From: Simon Davis
Sent: 26 November 2019 11:08
To: [REDACTED]
Subject: RE: Yapton Metal Company - ref Y/61/19/PL

Subject: Yapton Metal Company - ref Y/61/19/PL

Site Plan (Proposed) 1:200

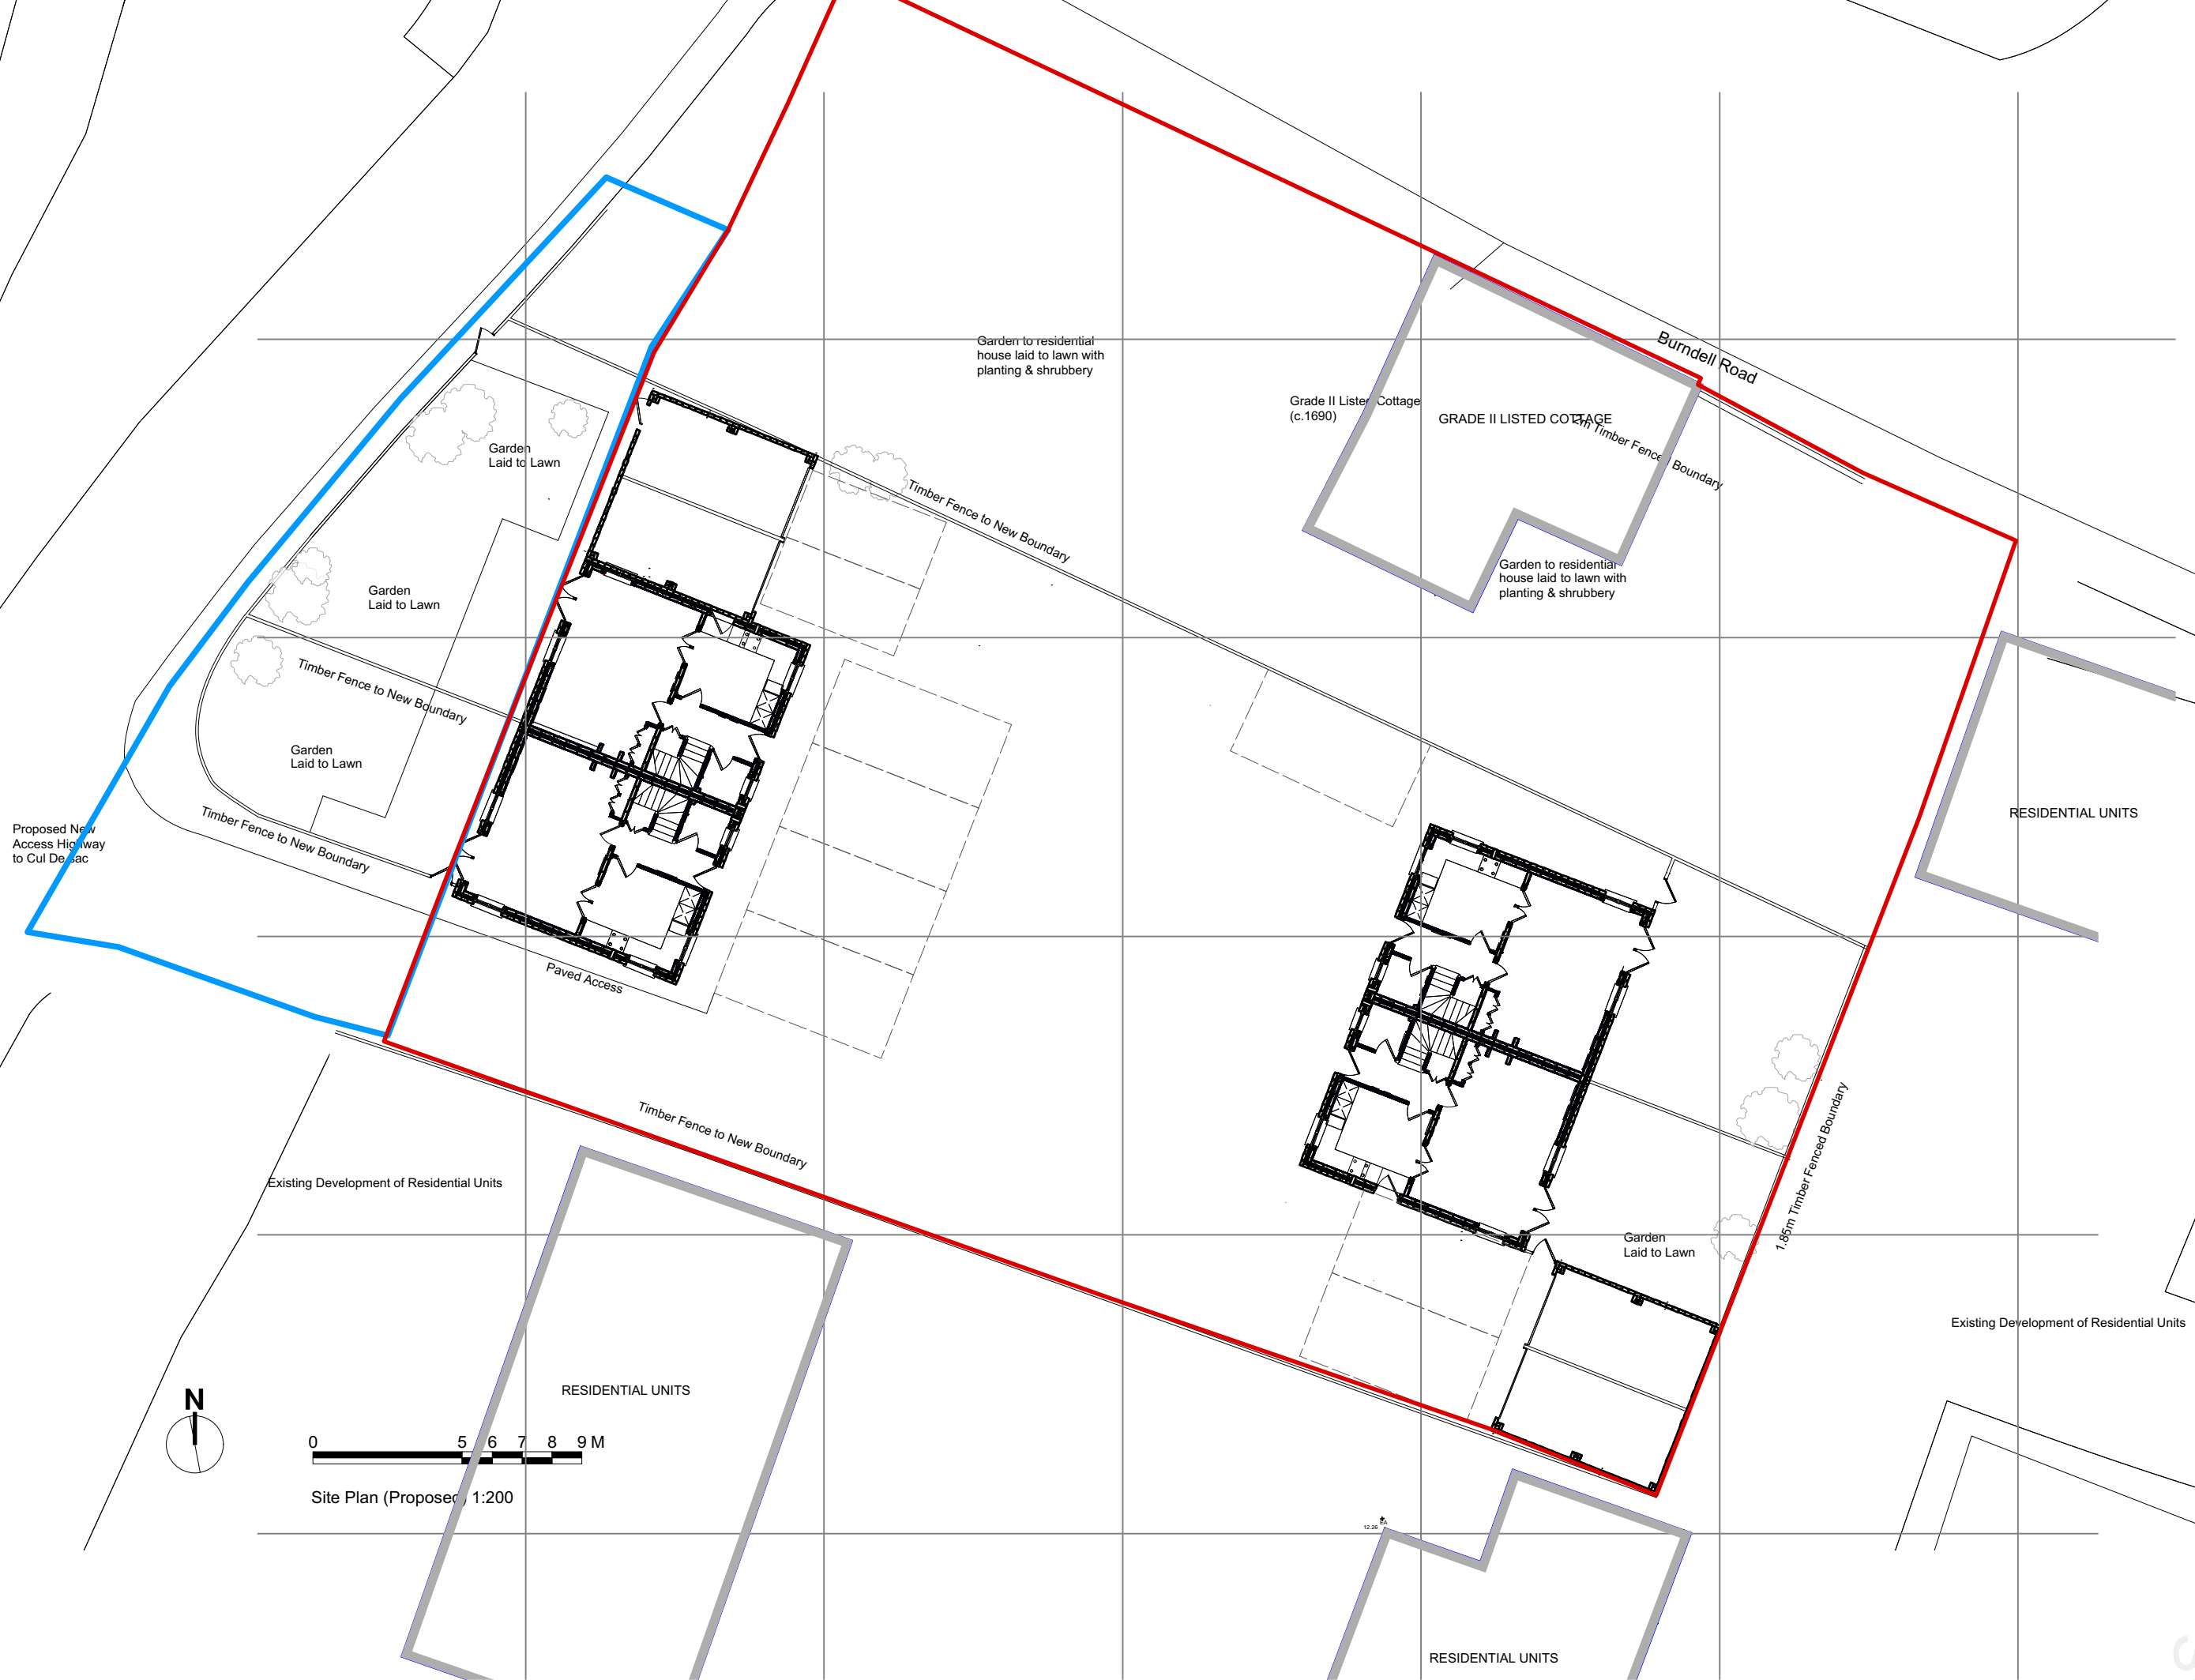
I am proposing to delete the tree protection condition entirely as it no longer serves a useful purpose.

The conditions then requiring discharge will be the two drainage ones, planting and cycle storage (I note this will be in the garages however you will need to provide us with details of storage racks).
